GROVE FARM

TRANSPORTATION & HIGHWAY SUPPLEMENTARY REPRESENTATIONS No.2

**HIGHWAYS ENGLAND
DEVELOPMENT CONSENT ORDER APPLICATION (DCO)
FOR
M25, JUNCTION 28 IMPROVEMENT SCHEME**

Redwood Reference: PMcL/3396d3/April 2021

**Fig 3.1 - HE Indicative alignment of amended Grove Farm egress (Change 8)**

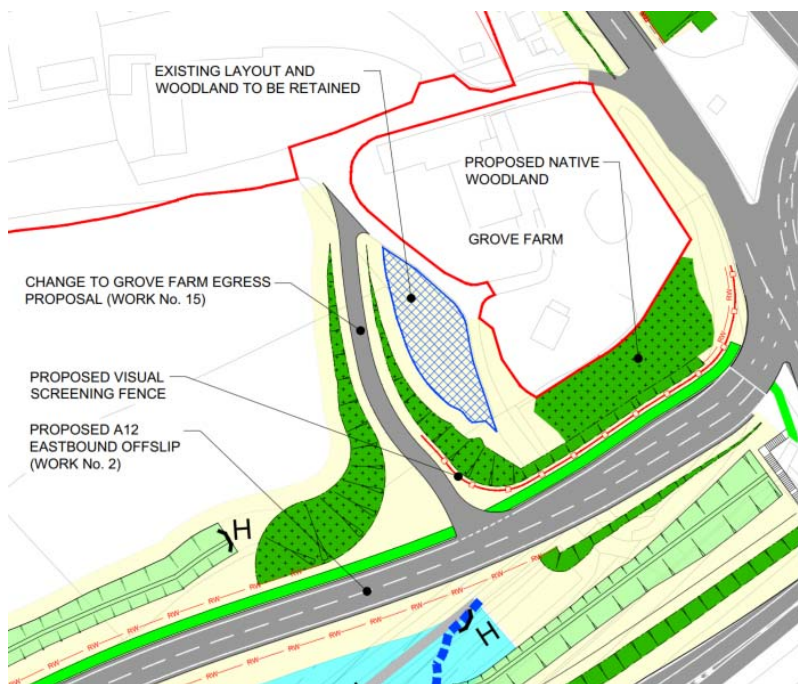
- 3.3 HE has confirmed they are assessing the feasibility of providing an amendment to the alignment of the Grove Farm egress. **Figure 3.1** shows a blue dash of the current potential line of an amended farm egress currently being investigated by HE:

3.4 Grove Farm welcomes this response from HE with regards alteration of the farm egress onto the A12 eastbound off-slip as the relocation of the farm egress will:

3.5 It is confirmed by Grove Farm that all Grove Farm land required for a change request for the amended farm egress proposals onto the A12 eastbound off-slip can be made available to HE for the construction of the amended farm egress. Grove Farm request that the distance between the farmhouse and the egress road be maximised.

- i) The closure of the current amended egress from Grove Farm to the A12 eastbound off-slip;
- ii) Construction of a new dedicated egress from Grove Farm to the A12 eastbound off-slip with alteration of on-site roads to suit;
- iii) Provide Grove Farm with a copy of the CAD topographical survey and CAD 3d survey as an internal document;
- iv) Provide proposals at scale 1:1000 [ExA question - PC2.1].

**Figure 3.2 – Grove Farm's suggested location for extra noise attenuation fencing**

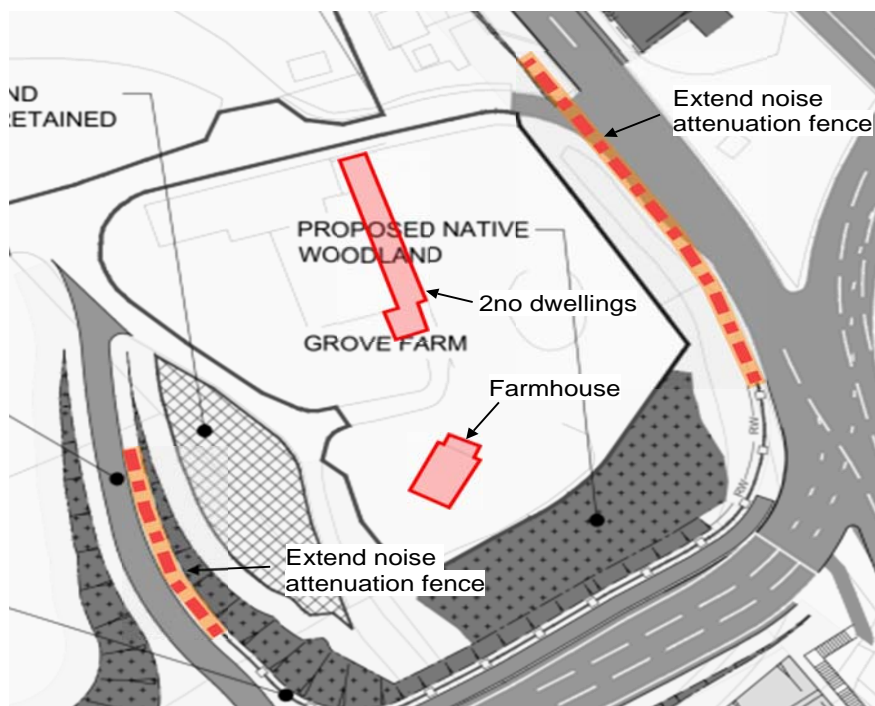
- 4.1 The owners of Grove Farm remain concerned that no permanent noise mitigation measures are included in the HE Scheme surrounding Grove Farm. Our **Drawing No. REDW-3396-115**, previously issued, showed Grove Farm’s suggested location of permanent noise attenuation barriers which would contribute towards the enhancement of Grove Farm’s environment and mitigate increased environmental traffic noise brought about by the HE Scheme. HE proposals for additional landscaping or standard visual fencing will not provide any material benefit for traffic noise reduction [ExA question - PC2.3 (ii)]. HE has dismissed any need for noise attenuation barriers based upon their noise assessment and has not worked with Grove Farm with a view to include a noise attenuation barrier in the HE Scheme; only suggesting visual fencing [ExA question - PC2.4 (ii)].

- 4.2 **Figure 4.1** shows an extract of our **Drawing No. REDW-3396-115** showing Grove Farm’s suggested line for permanent noise attenuation fence (highlighted in orange):

- 4.3 The HE Scheme will not reduce traffic flows and associated future traffic growth on the new and closer A12 eastbound off-slip or the M25 northbound on-slip both next to Grove Farm. The highlighted noise attenuation barrier shows the fence returning into the site at the existing farm entrance and our suggested farm egress. These barrier returns will mitigate against increased noise from traffic flows on the closer A12 eastbound off-slip and the M25 northbound on-slip.

- 4.7 Grove Farm requests that the ExA require HE to include an appropriate and visually pleasing noise attenuation barrier as environmental mitigation along the coloured line suggested in **Figure 4.1**.
